Land at
Lingards Road
Slaithwaite
Huddersfield
HD7 5HY

Date: 29-Oct-2025
Our Ref: 2023/93464

**Application for Approval of Details Reserved by Condition
Town and Country Planning Act 1990
Planning (Listed Buildings and Conservation Areas) Act 1990**

SB HOMES
LINGARDS ROAD
BRIDGE DETAILS

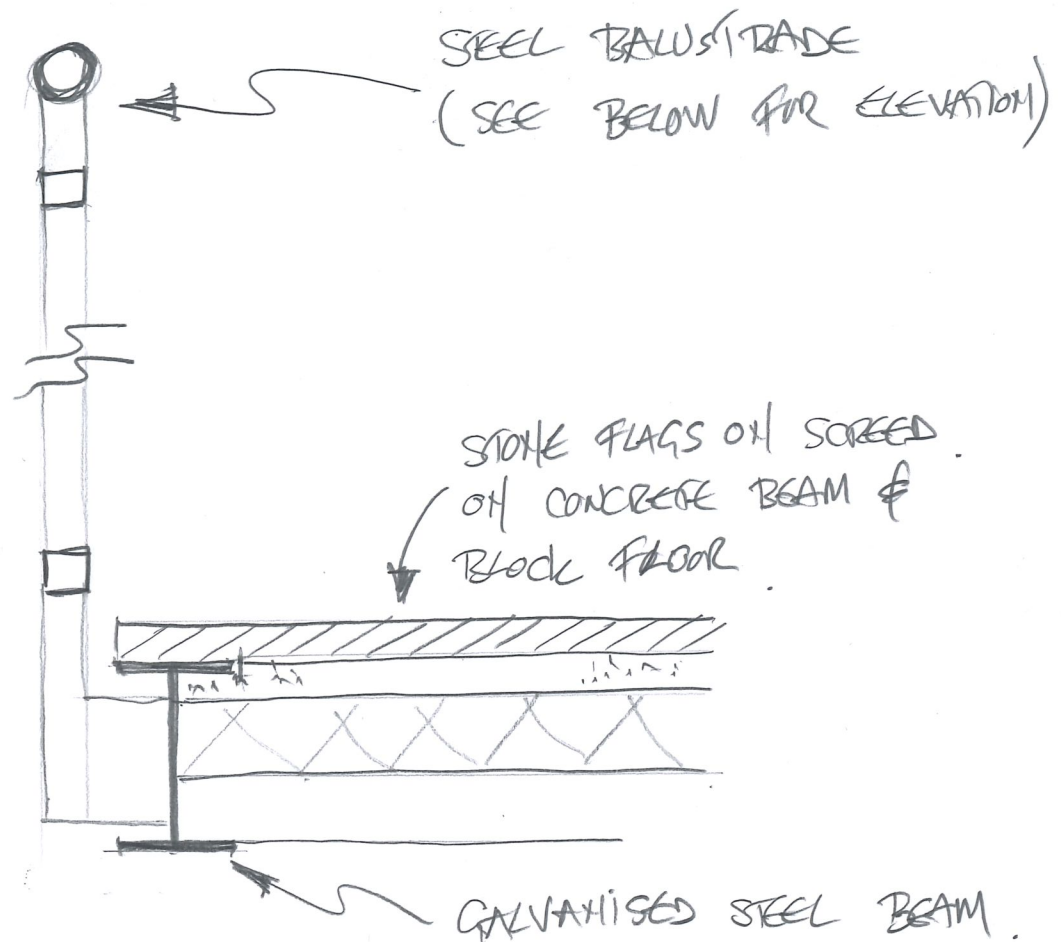
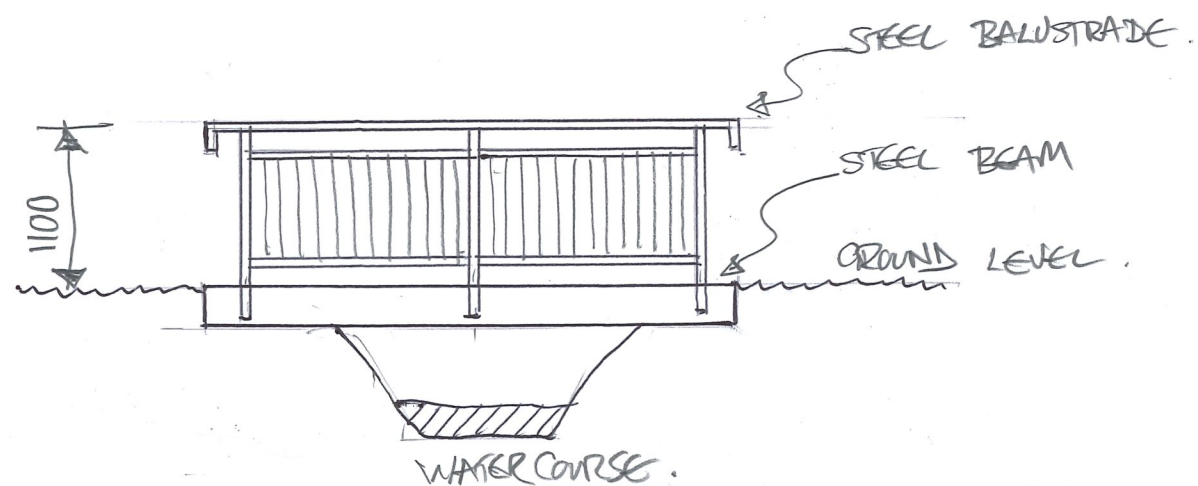
The design of the bridge is not considered problematic. However, the submitted drawing lacks the following information:

- Confirmation of the proposed colour and finish of the steel. Of note, this should include the 'steel beam' shown at ground level.
- Confirm the width and length of each bridge.

APPENDIX 3:
R/2646/1G Landscape Masterplan

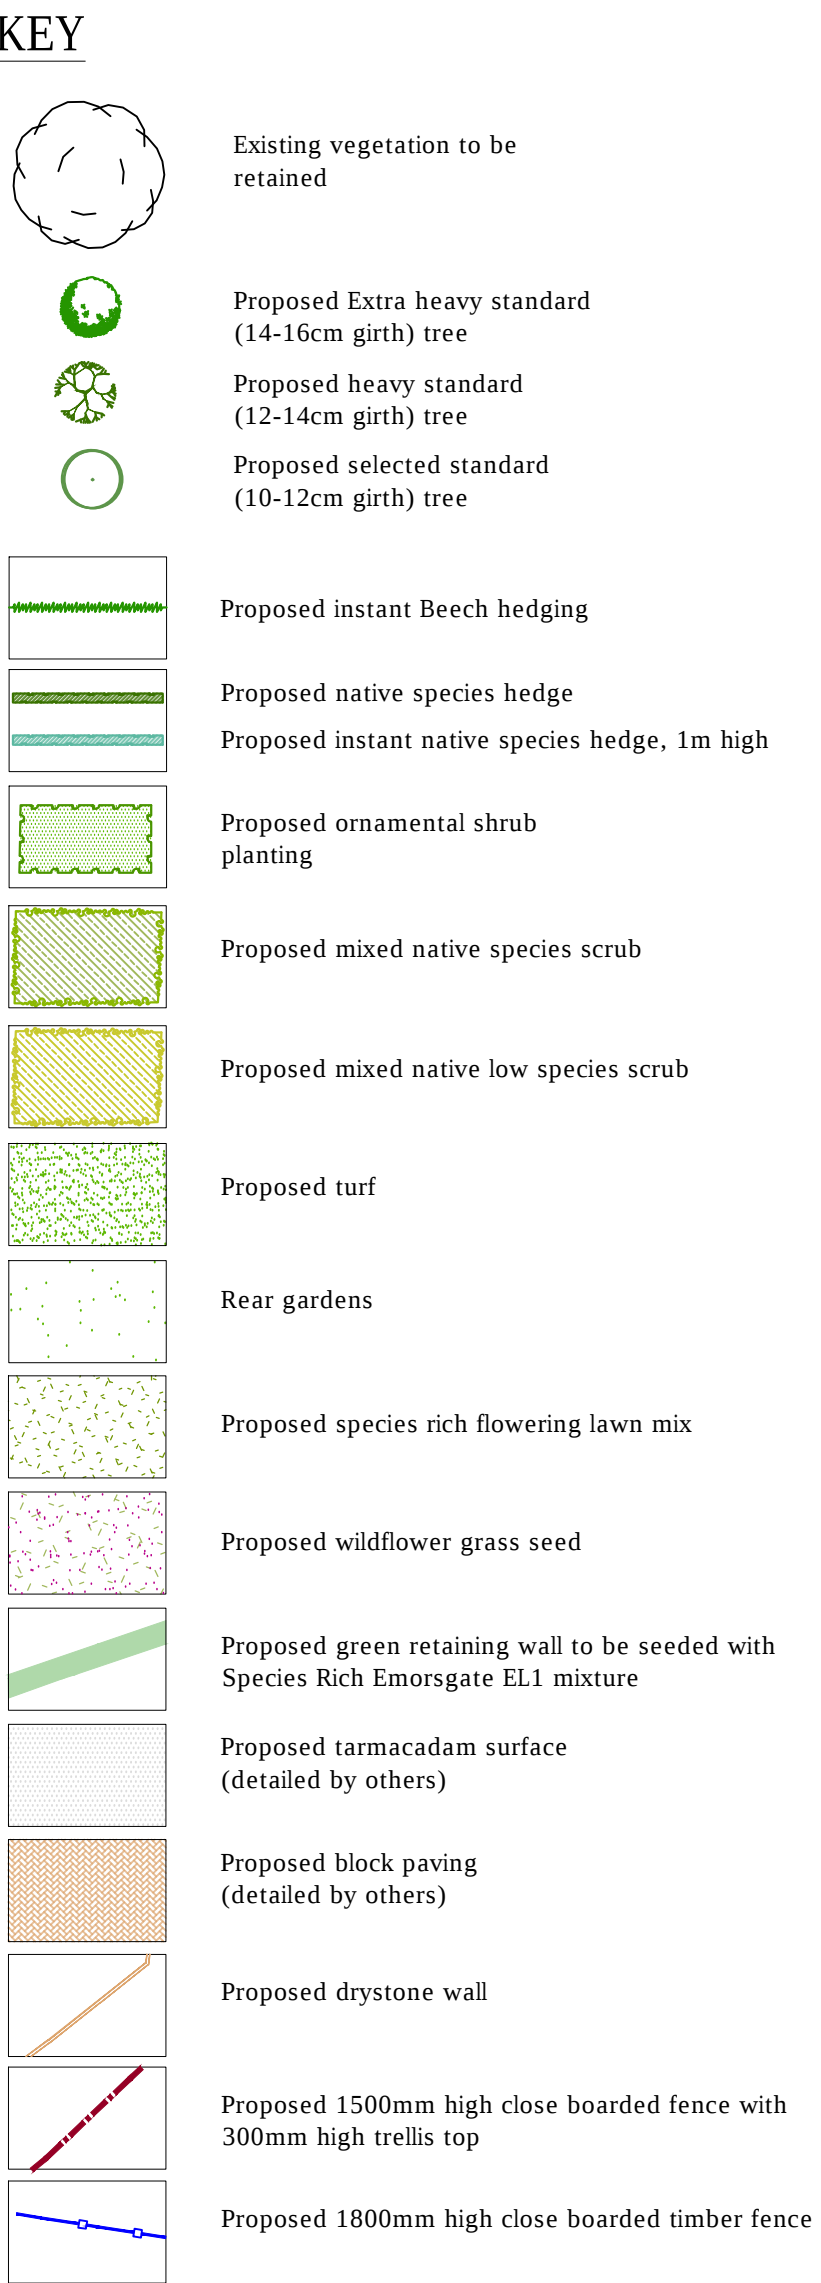
27(a)(a): Additional tree planting to former a more substantial screen (or justification why this cannot be provided) is expected. This is to enhance the visual appearance of the site, while offering greater screening to adjacent residents.

27(a)(b) and 27(b)(c): Both a more detailed and robust planting and hard-landscaping strategy is expected. The area subject to this subsection of the condition is at the site's point of access, where a high quality and attractive design is required, while ensuring the landscaping measures both protect and do not prejudice the amenity of occupiers of number 45 Lingards Road through overbearing or overlooking. Sufficient screening is needed. What is 'sufficient' needs to be considered and justified by the submission, but is expected to be a mixture of hard and soft landscaping. Engagement with the occupiers of 45 Lingards Road is recommended (but for the avoidance of doubt, this is not a mandatory requirement). Smaller scale site plans (1:50 or 1:100), typical elevations, and cross sections between the new road, boundary treatment, and 45 Lingards Road are expected.

27(b): The 1.8m fence (1.5m fence and 0.3m trellis) proposed to the rear/side of plot 42 (adjacent to the development's estate road) is not considered appropriate in this prominent location. A stone wall to match the adjacent dwellings would be appropriate here.

27(b)(a): To the site's west boundary, into the adjacent field, the boundary treatment proposed is 'existing drystone boundary wall to be retained and repaired as necessary'. While this is not necessarily problematic, and while a typical 1.8m high fence is unlikely to be supported here, officers question whether the proposal is sufficient to secure the amenity of future residents, including limiting opportunities for crime. Officers would suggest that a hedgerow be included behind (within the site) the repaired drystone wall, to enhance the boundary.

27(b)(b): The submitted plans state 'existing drystone boundary wall to be retained and repaired as necessary'. The site is at a higher level than Lower Wood Farm, therefore a carefully designed boundary treatment which preserves occupiers' amenity, while responding to the building's Grade II listed status, is expected. The simple statement on the plan is insufficient to give officers confidence this has been achieved. Officers require a more thorough assessment to demonstrate the most suitable boundary treatment is being proposed to balance these requirements. Officers also advocate for a discussion with the residents of Lower Wood Farm, as their input would be welcomed (but for the avoidance of doubt, again, this is not a mandatory requirement).

27(c): No dedicated timescales for the delivery of the landscaping and public open space areas have been provided. The CEMP includes a site-wide phasing plan, however, this is too broad (it generally relates to construction phasing) to be suitable for condition 27. For example, the plans do not confirm when the public open space areas would be brought forward and ready for use, and it is noted that one public open space area is to host the site's contractor parking and material storage through phase 3 (the final phase). No details have been submitted confirming when the landscaping of this public open space area would be provided after the material storage and parking is no longer required. A dedicated timescale delivery plan for each area of public open space is necessary.
